**FFERM WYNT ALLTRAETH AWEL Y MÔR ARFAETHEDIG / PROPOSED AWEL Y MÔR OFFSHORE WINDFARM**

**CYFEIRNOD YR AROLYGIAETH GYNLLUNIO / PLANNING INSPECTORATE REFERENCE: EN010112**

**RE: NATURAL RESOURCES WALES' WRITTEN SUBMISSION FOR DEADLINE 3a**

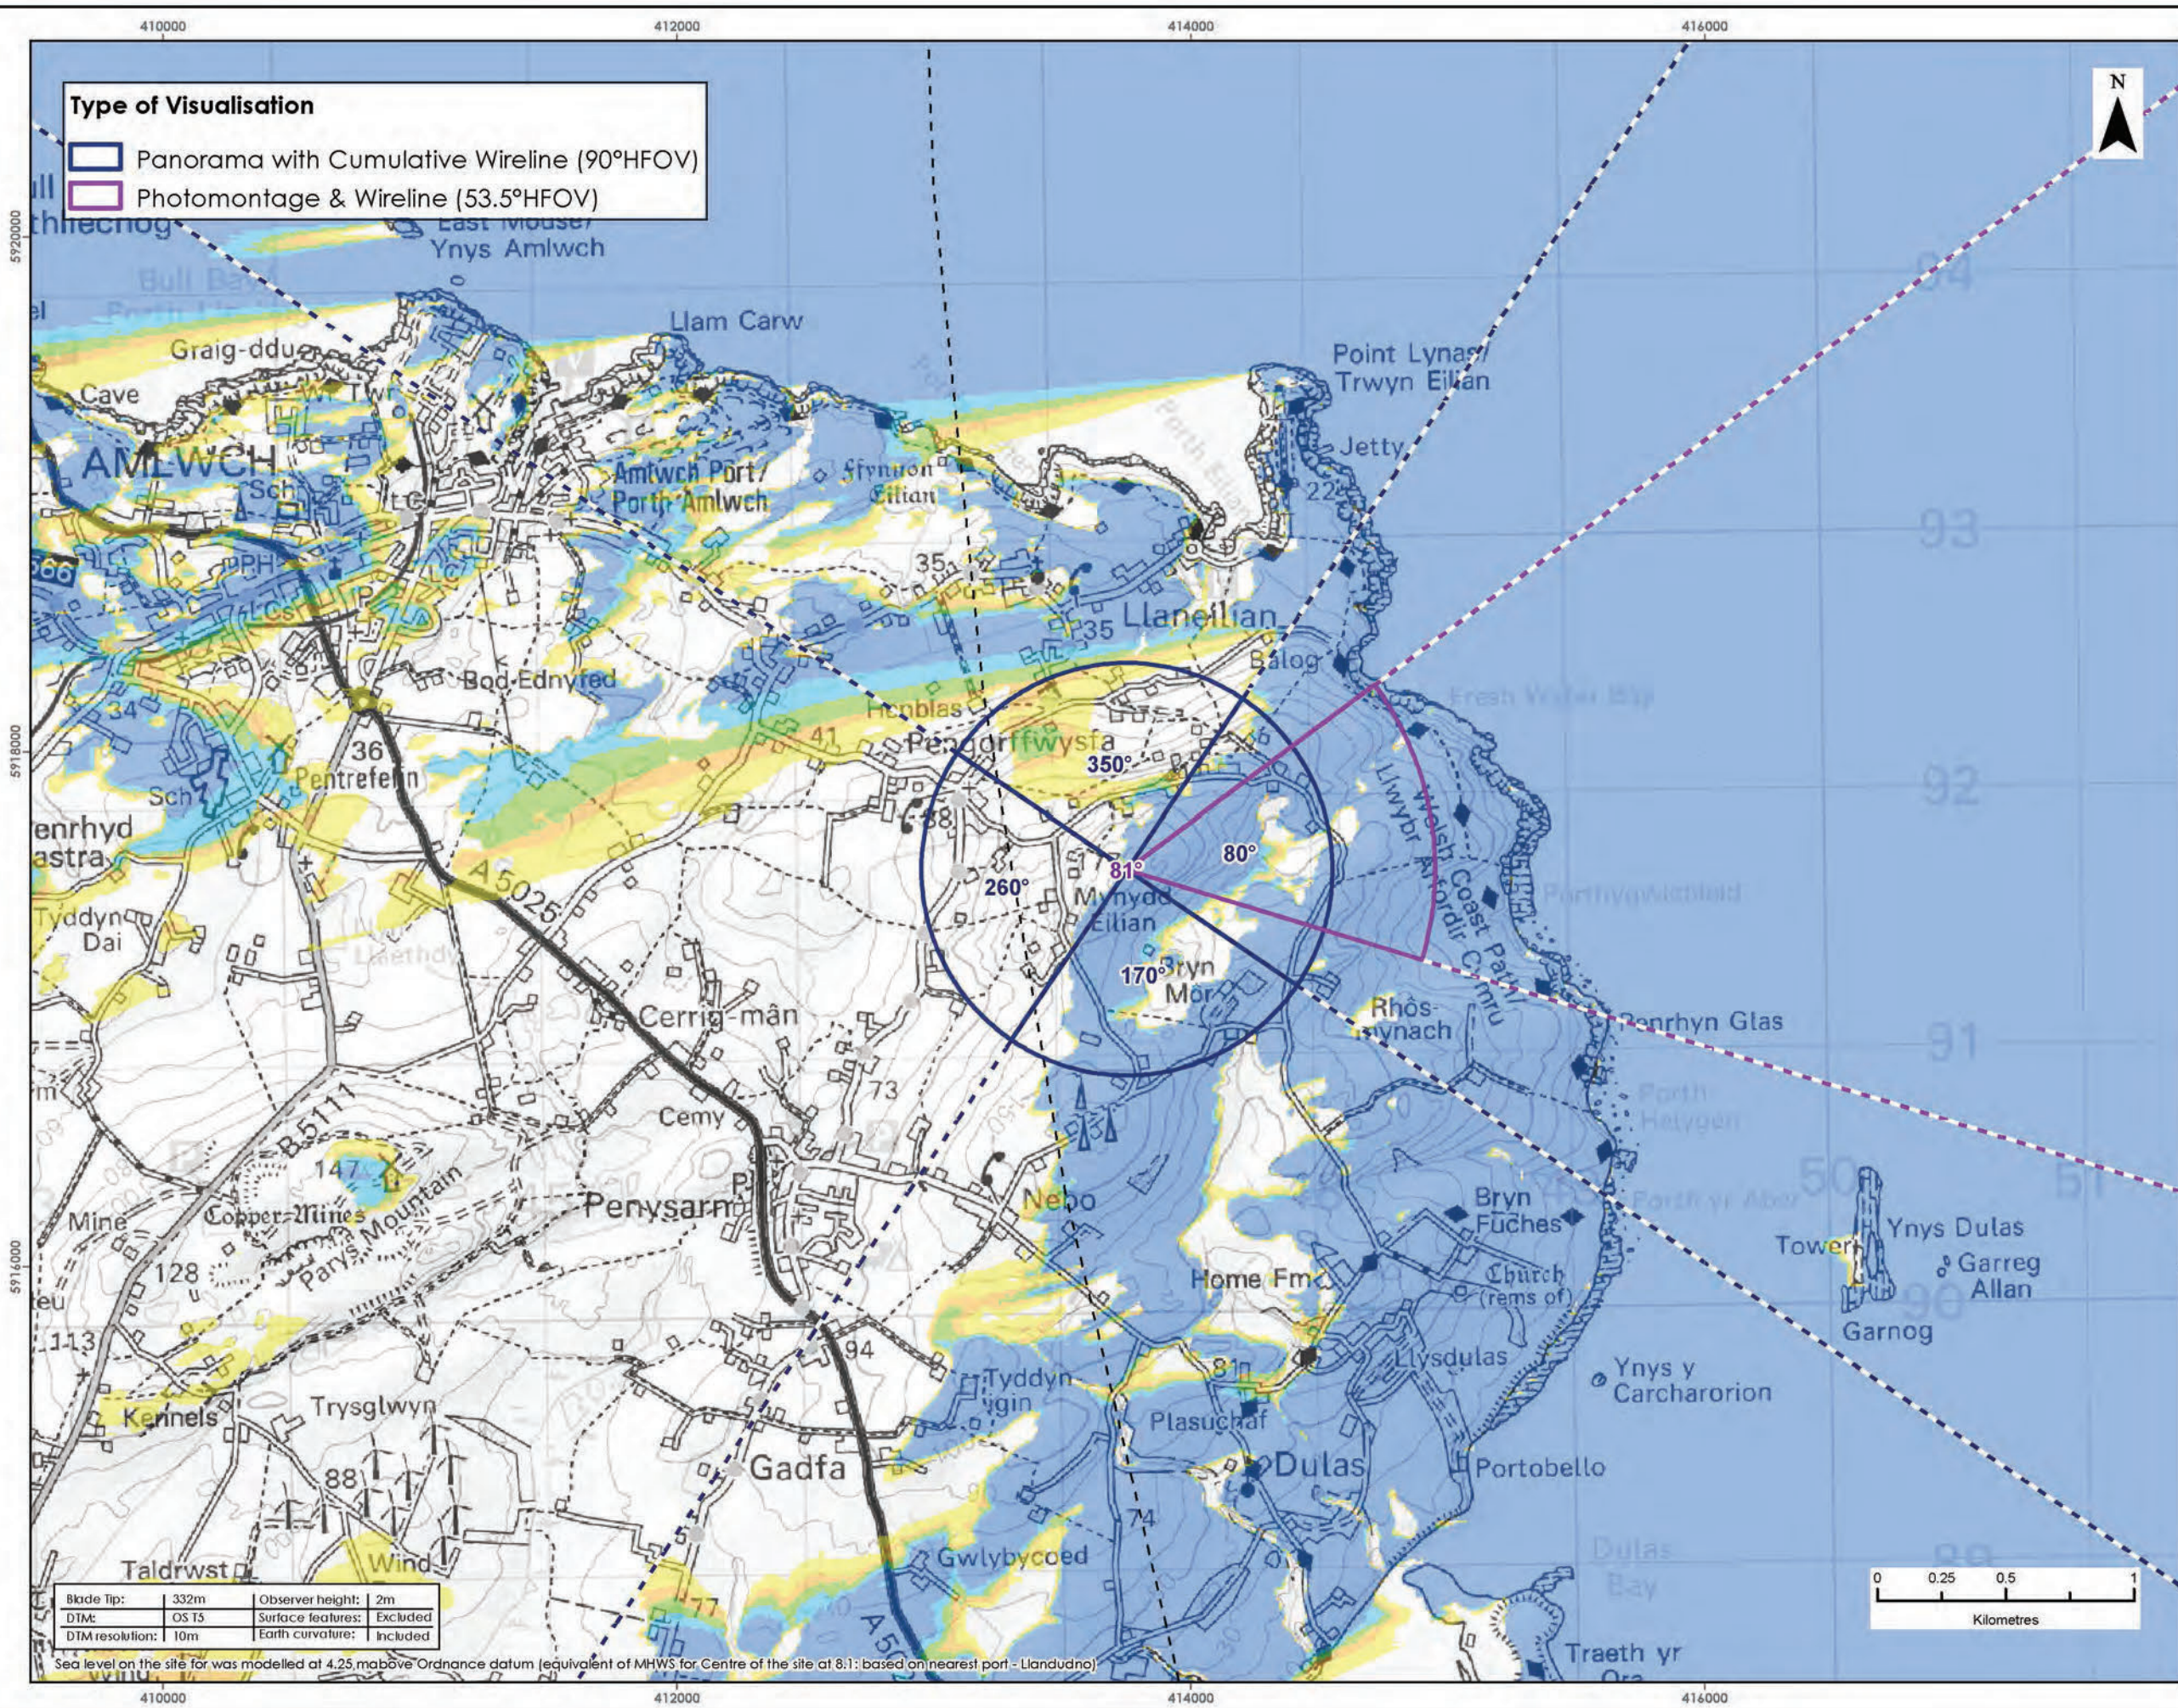
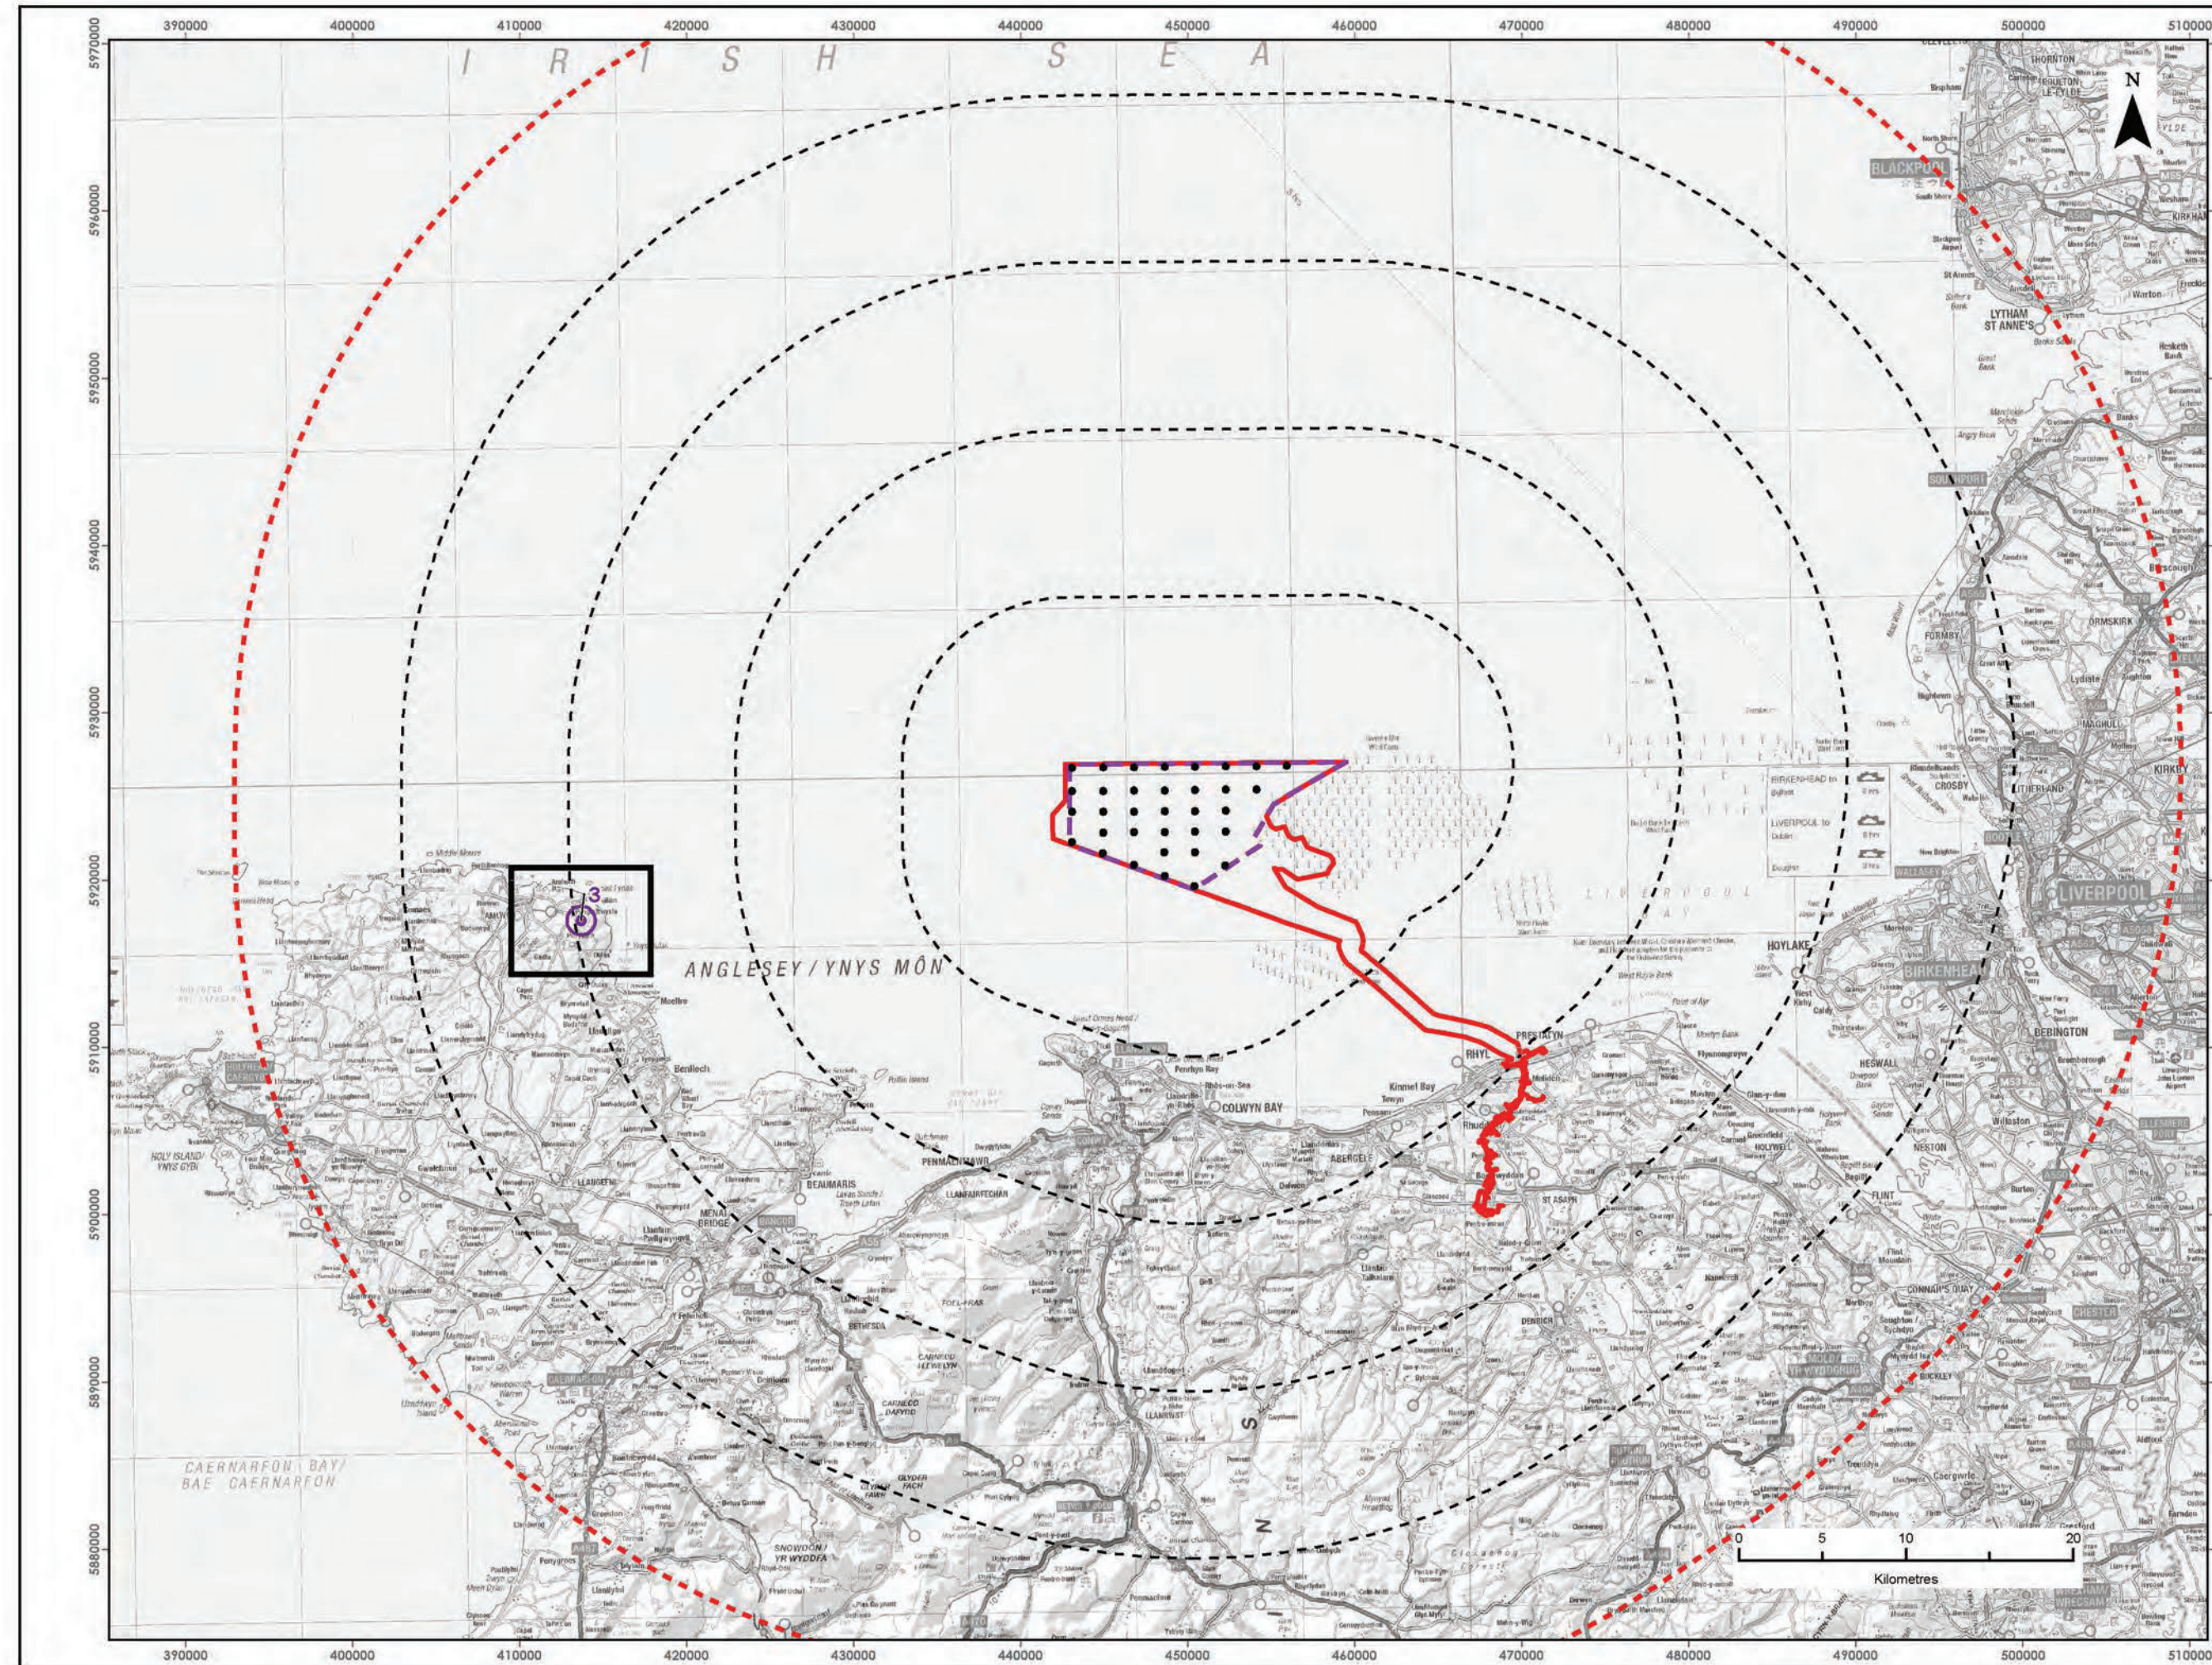
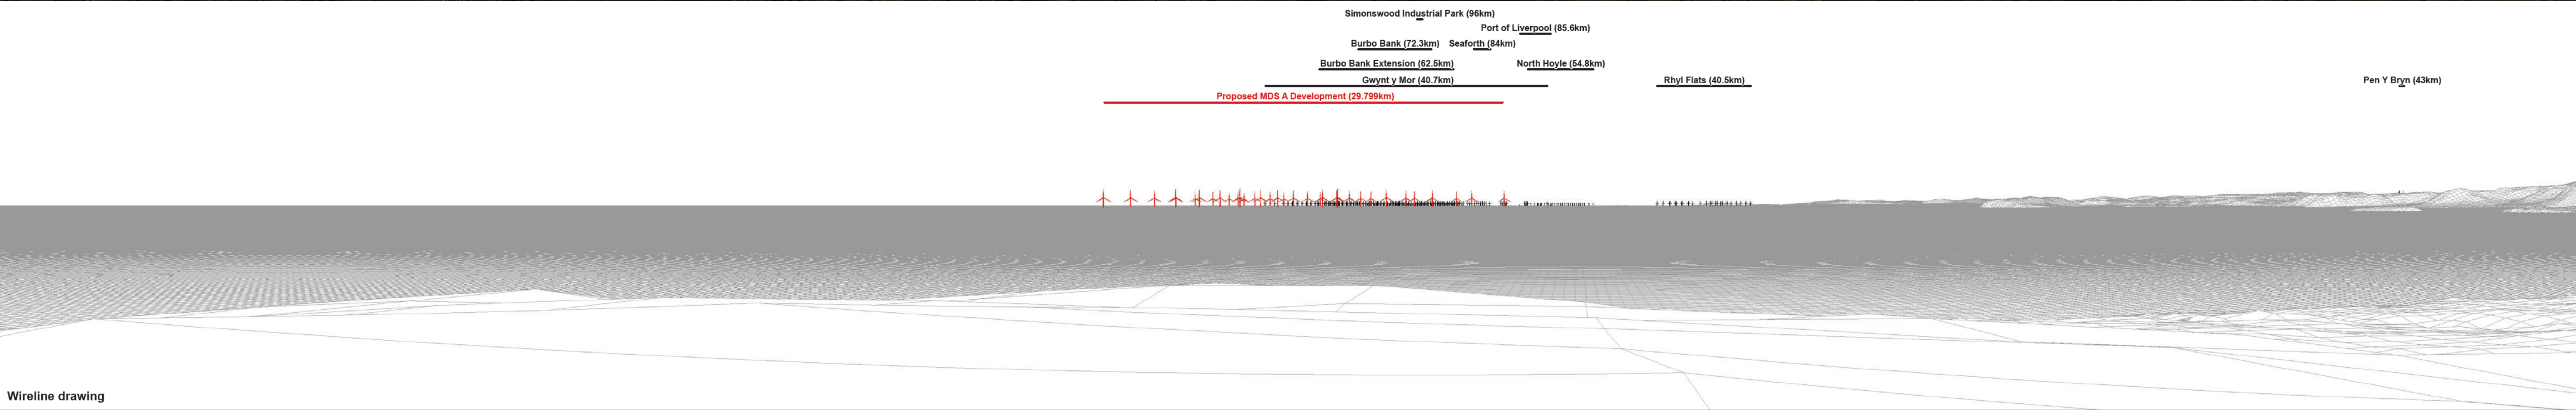
- 2.5. In relation to viewpoints (VP) 1 (Porth Llechog/Bull Bay) [APP-230], VP2 (Trwyn y Balog/ Point Lynas) [APP-231] and VP3 (Mynydd Eilian) [APP-232], we consider that the effects at these viewpoints have been underestimated in the SLVIA. We consider the effects to be of low-medium magnitude, and that this level of magnitude combined with high sensitivity should lead to an assessment of moderate adverse effects, which we consider significant. We consider the threshold for significance has been reached for VPs 1, 2 and 3.

- 2.6. From these viewpoints, highly sensitive receptors (e.g., walkers on the coastal path) are focused on the coastal landscape and sea views. Although there are large-scale sea views, the scale and nature of the development would make it very noticeable and focus attention upon it. Sea views and the coastline are the key focus of views in the predominantly coastal AONB and sea views are currently untrammelled by development or any other significant human activity, apart from the occasional ship. This part of the AONB is relatively remote and tranquil. The existing offshore windfarms to the east, including Gwynt y Môr, are extremely hard to discern even in fine weather and built development along the coastline is not similar in nature or scale to the proposed wind farm. The proposal would interfere with the appreciation of the open sea and coastline including views of coastal landforms and the mountains of Eryri (Snowdonia). Windfarms inland, as seen from Mynydd Eilian, are smaller scale and associated with the inland rural landscape and not sea views and the coastline.
